Subject: Planning Application Ref. WA/63/19/PL - Erection of 8 Detached Dwellings on Land South of Arundel Road, Walberton, West Sussex, BN18 0QP

My client has recently been in direct discussions with Mr & Mrs Hughes, who currently reside in Foxwood Cottage, to the west of the application site – I gather Mr & Mrs Hughes have submitted comments on the site's planning application, which my client is keen to address; and I am therefore pleased to attach the following revised plans, to form part of the application before you:

Drawing No : PL_WL_01

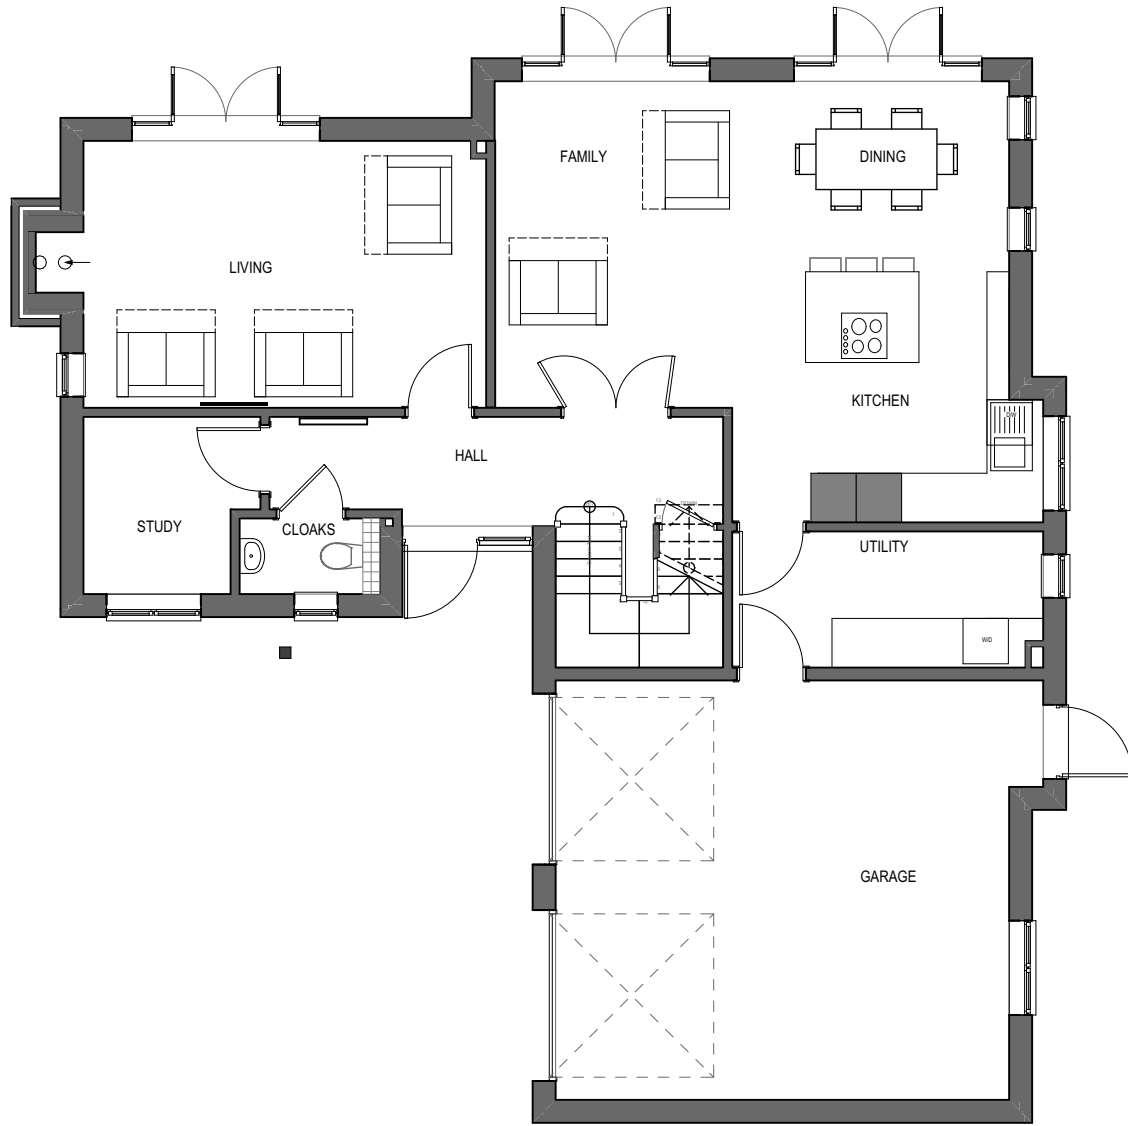
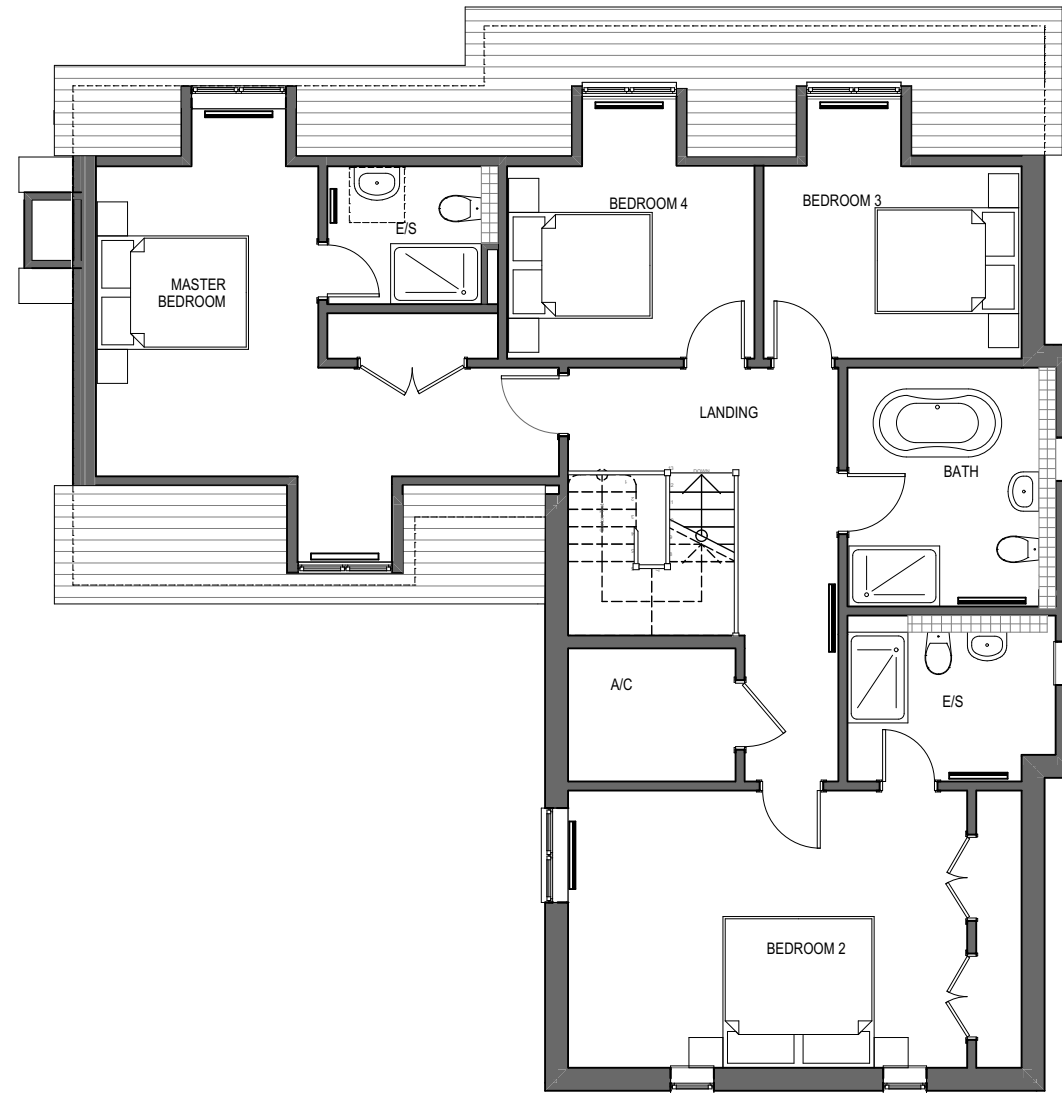
1. Unit 1 has been changed from a 5 bedroom unit to a 4 bedroom unit. The west facing dormer window for bedroom 2 has been omitted, to avoid any overlooking to Foxwood Cottage. All first floor windows in the unit's west elevation will now be obscure glazed windows to bathrooms and can be conditioned as such.

2. Units 1 and 2 have had a 'Velux' style rooflight added to their master bedrooms' en-suite bathroom.
3. Site Layout plan ref. 54_17_100_B has been revised so that the roof plans for Units 1 and 2 match the revisions described in items 1 and 2 above.
